From: Bruce Taunton
Sent: 29 October 2014 14:51
To: Planning.Responses
Subject: RE: Planning Consultation on: LU/312/14/HH

APPLICATION LU/312/14/HH
NO:

Registered: 14th October
2014
Site Address: 13 Irvine Road Littlehampton BN17 5LB

Description of Works: Raise height of existing front boundary wall.
This application may be determined under delegated powers by Littlehampton Town Council. This application affects the character and appearance of the Littlehampton Seafront Conservation Area.

NEW WALL TO FRONT
BOUNDARY

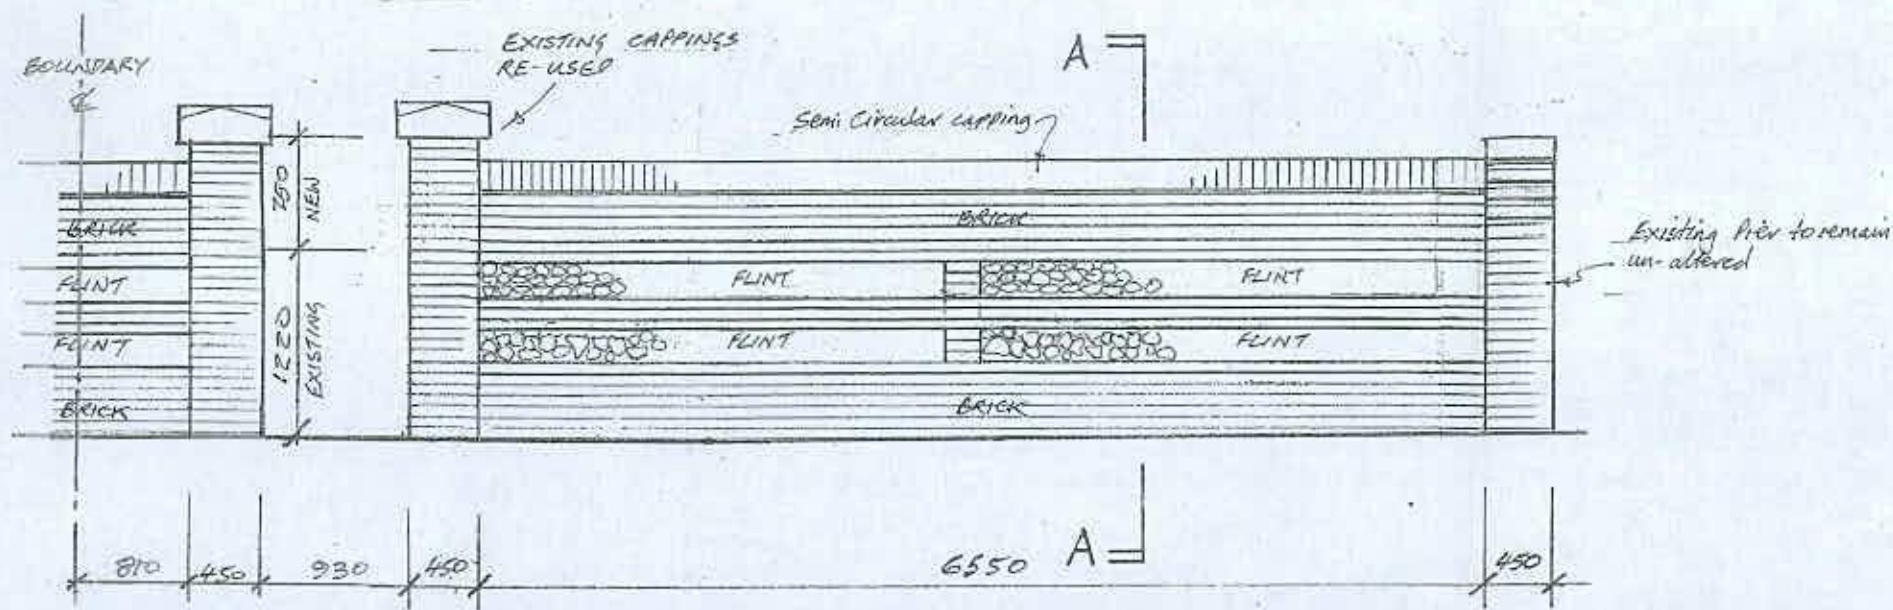
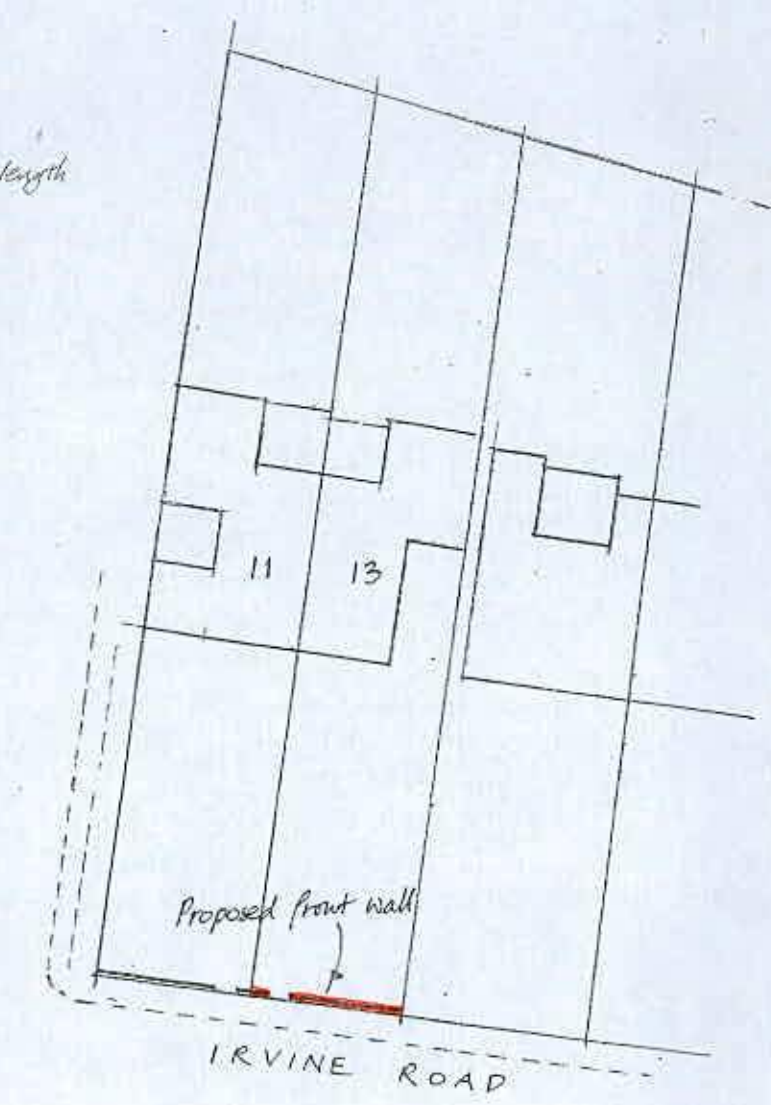
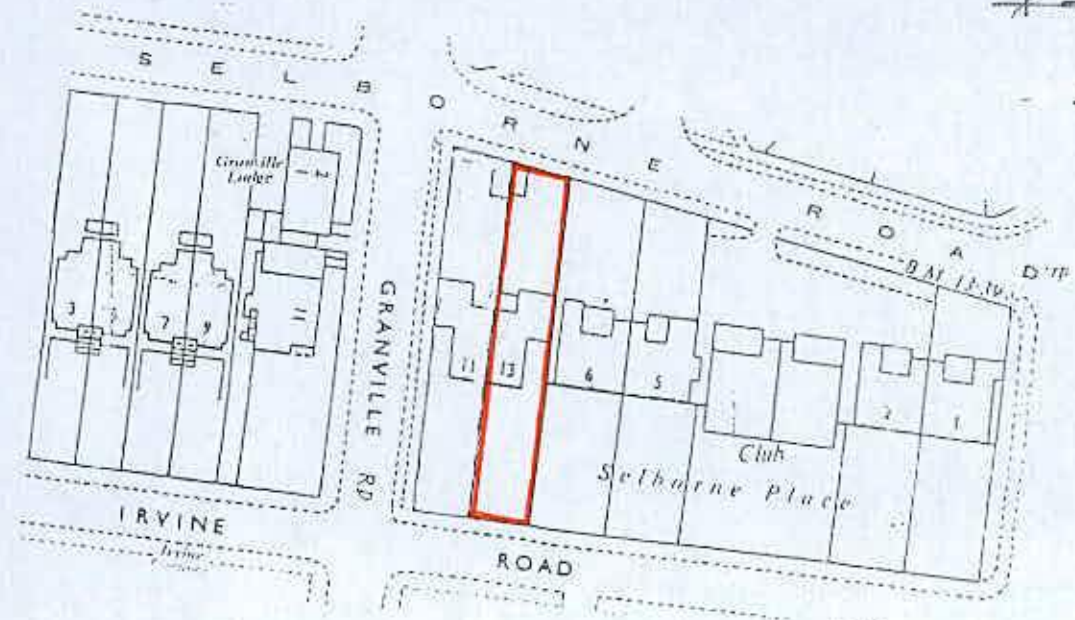
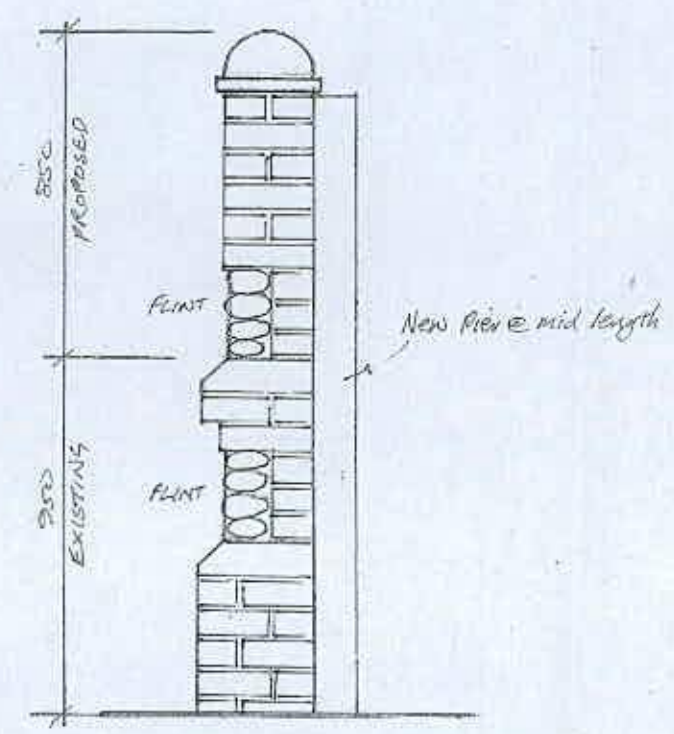
Boundary wall design required to prove adequacy under wind loads for the increased height. Existing wall foundation to be exposed and assessed for adequacy to support the additional load.
